FG/131/18/NMA

Application for a non-material amendment following a grant of planning permission. Town and Country Planning Act 1990

POINT 3. submit for consideration, a non-material amendment in respect of the full depth top hung obscurely glazed casement window unit in bedroom 2 North (furthest from the front extension).

Client		
MR M. & MRS S. HARMSWORTH		
Project		
PROPOSED EXTENSIONS 25 UPPER WEST DRIVE FERRING WEST SUSSEX BN12 5RG		
Drawing		
PROPOSED FLOOR PLANS & ELEVATIONS		
Scale	Date	Drawn
1:50 & 1:100 @ A1	17.05.17	TP
Drawing No.		Revision
1336/P02		E

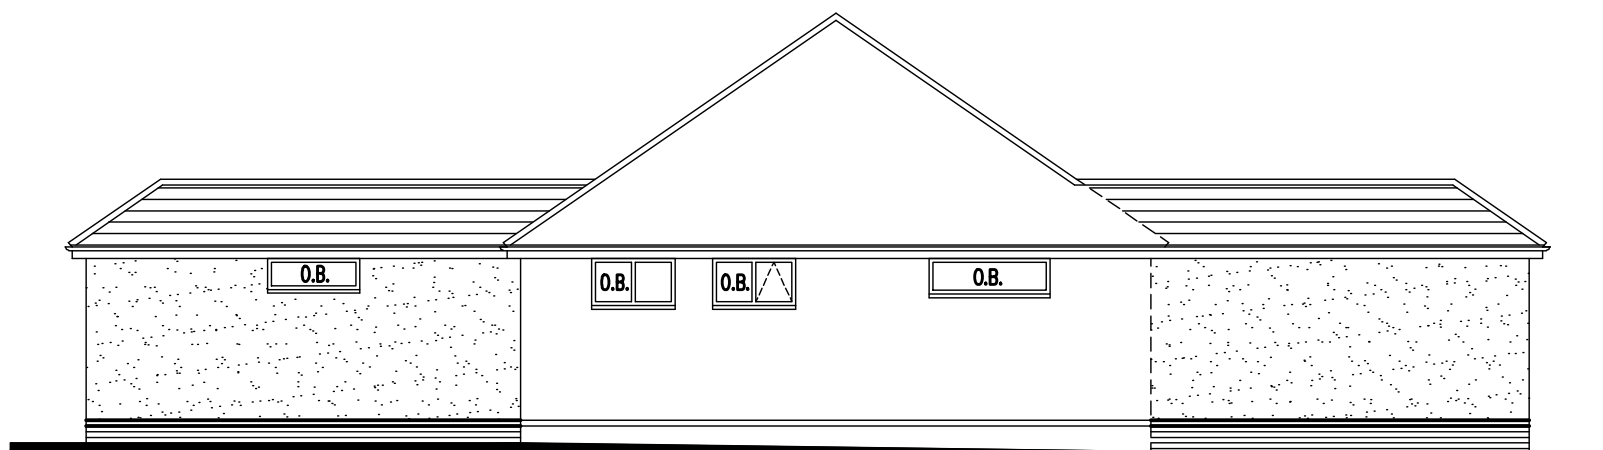
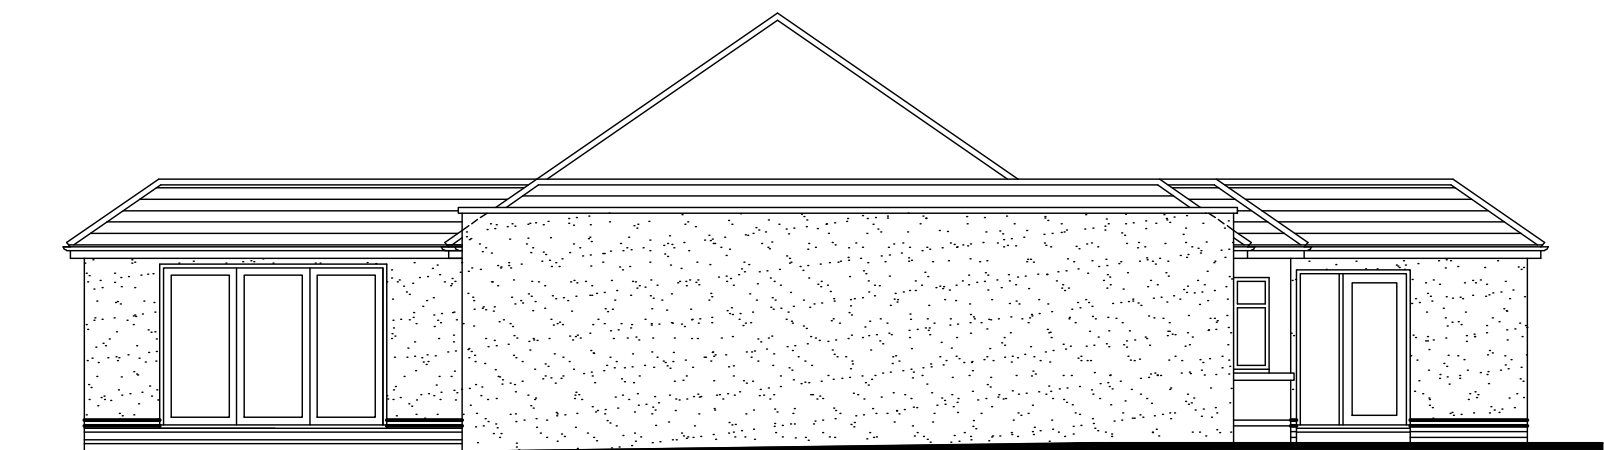
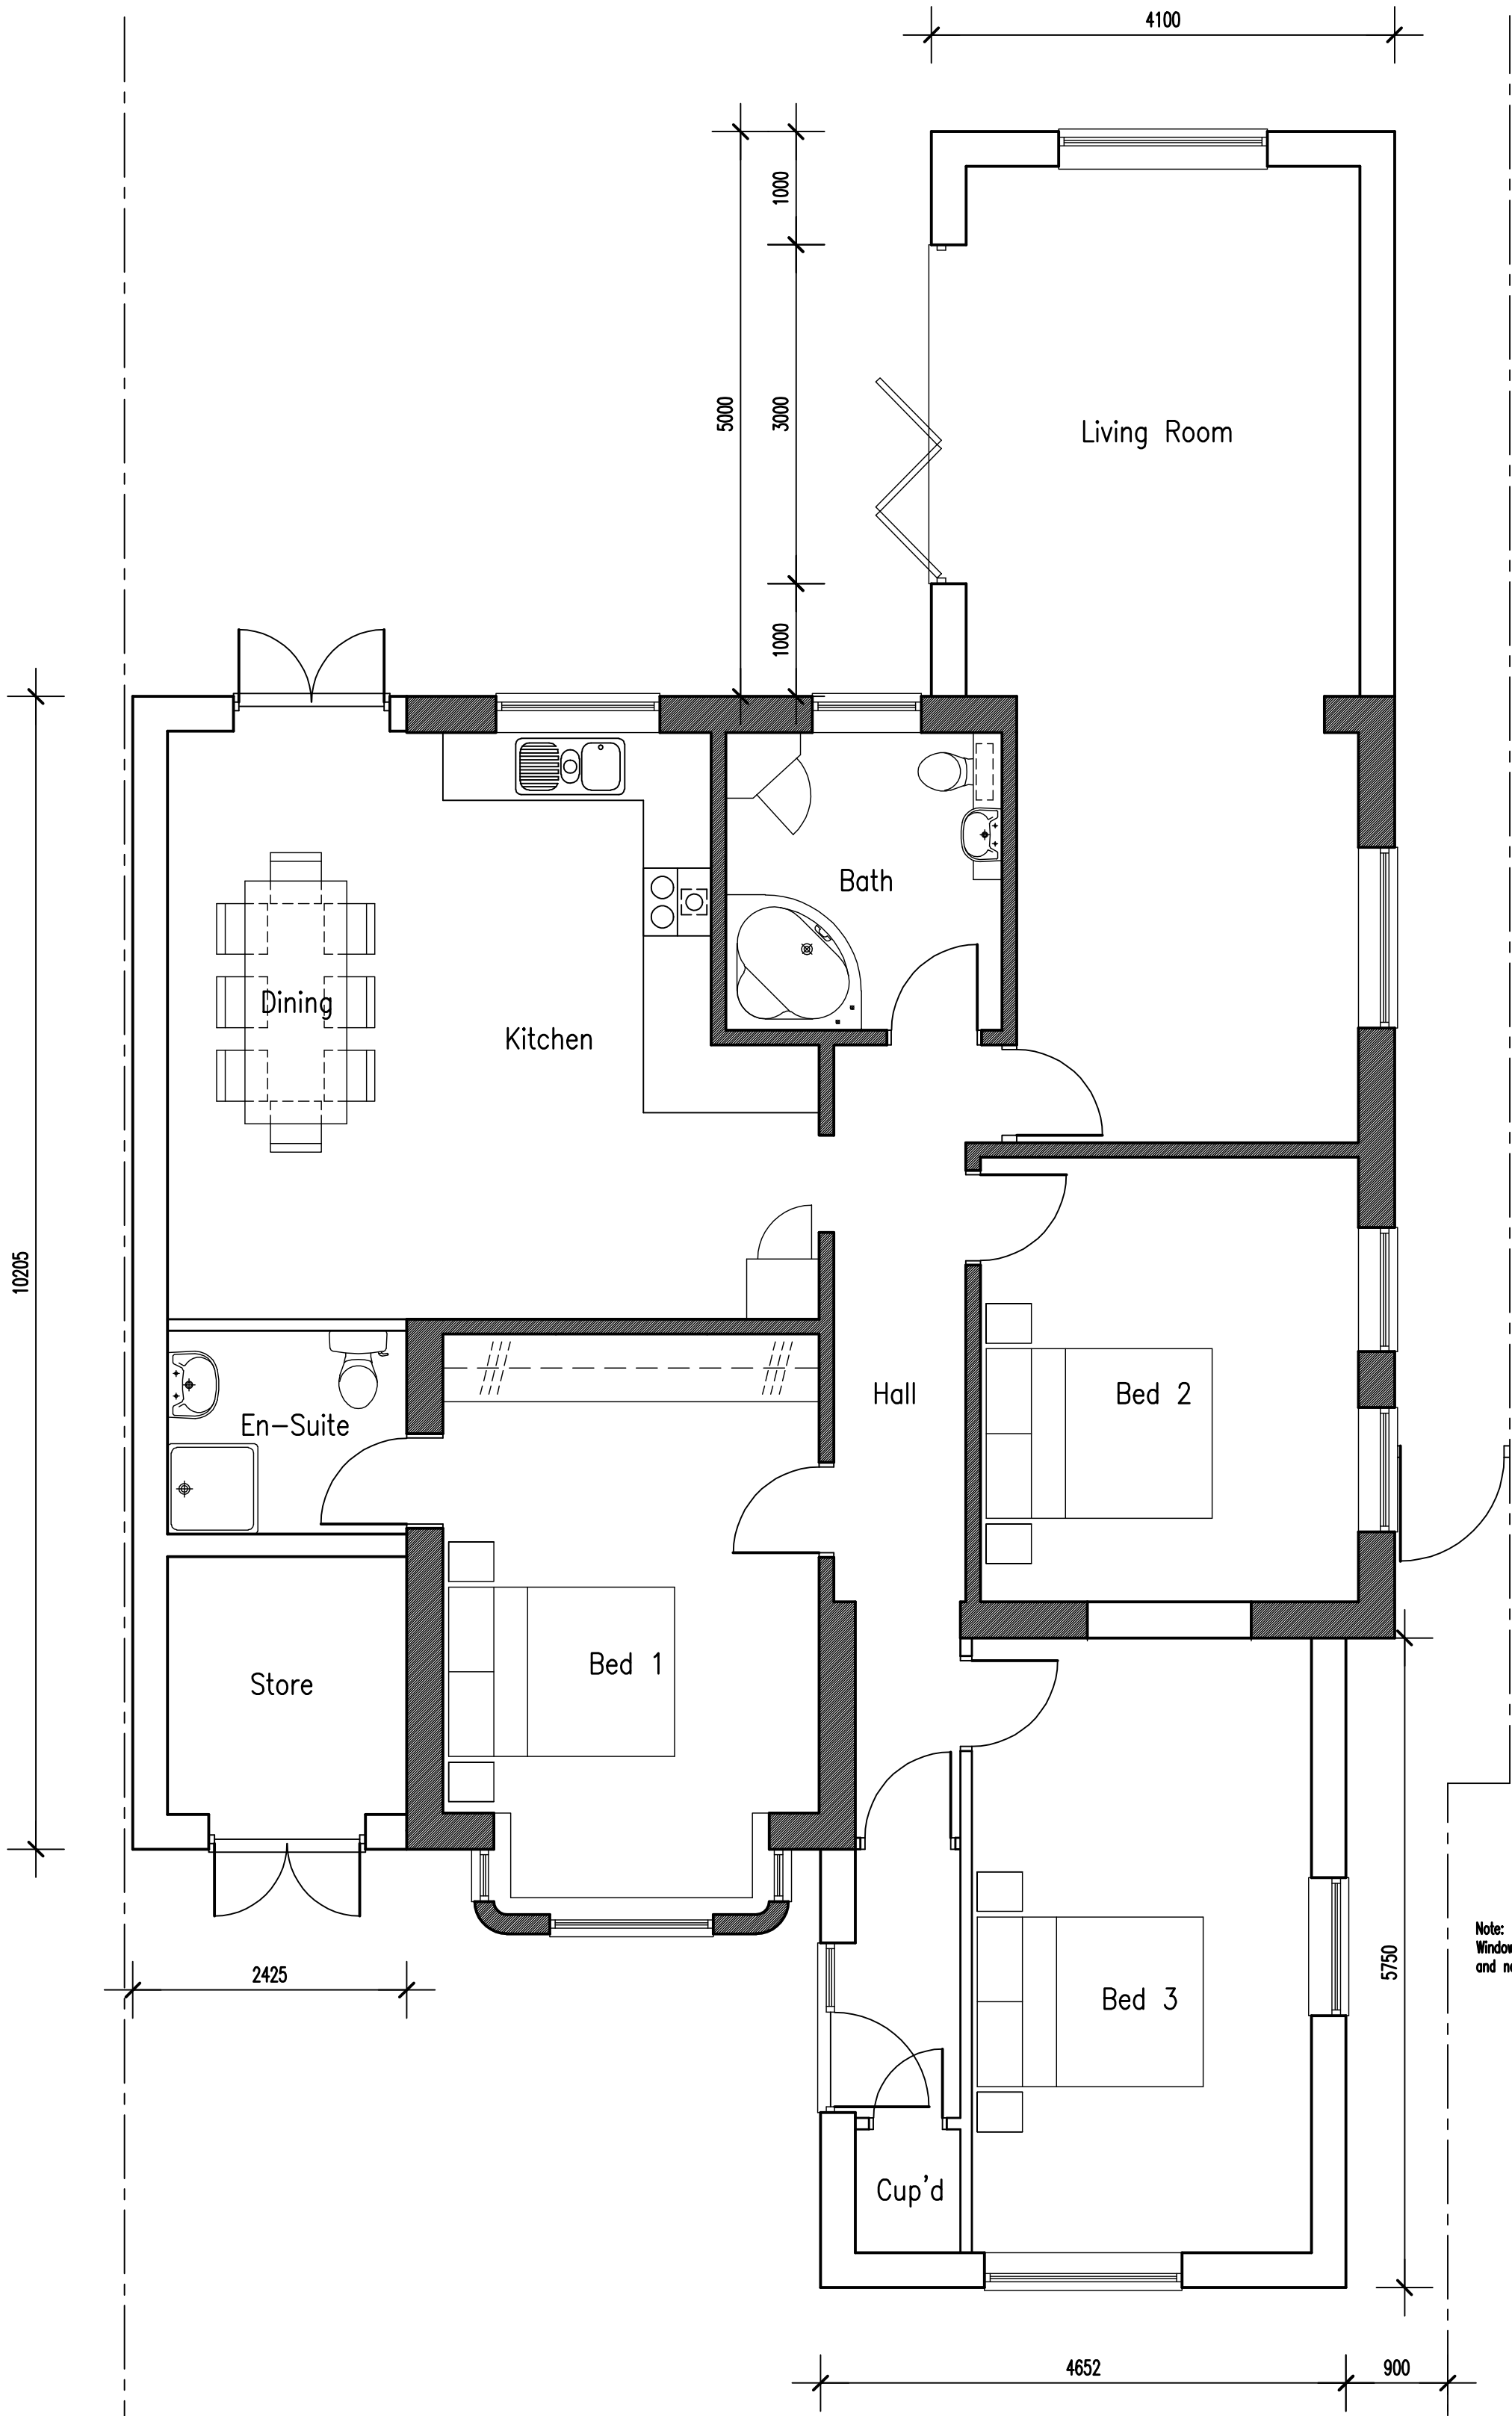
- POINT 4 STATED THAT ~~BOTH~~ 2ND WINDOW SERVING BEDROOM 2 FURTHEST FROM THE FRONT EXTENSION CONSIST OF 2 LIGHTS DIVIDED HORIZONTALLY WITH ONLY TOP LIGHT CAPABLE OF BEING OPENED - IT WAS DEEMED IMPRACTICAL TO MANUFACTURE & INSTALL SUCH A WINDOW, HENCE SPLITTING IT VERTICALLY IN 2 PANES, WITH ONLY ONE OPENER.

IT IS IMPRACTICAL TO MANUFACTURE SUCH A SMALL WINDOW SPLIT HORIZONTALLY. ALL PANES (NORTH FACING) ARE OBSCURELY GLAZED. ~~THE~~ BEDROOM 2 HAS ONLY ONE WINDOW THAT IS TOP HUNG & CAN ONLY BE OPENED. ALL OTHER GLAZING IS FIXED.
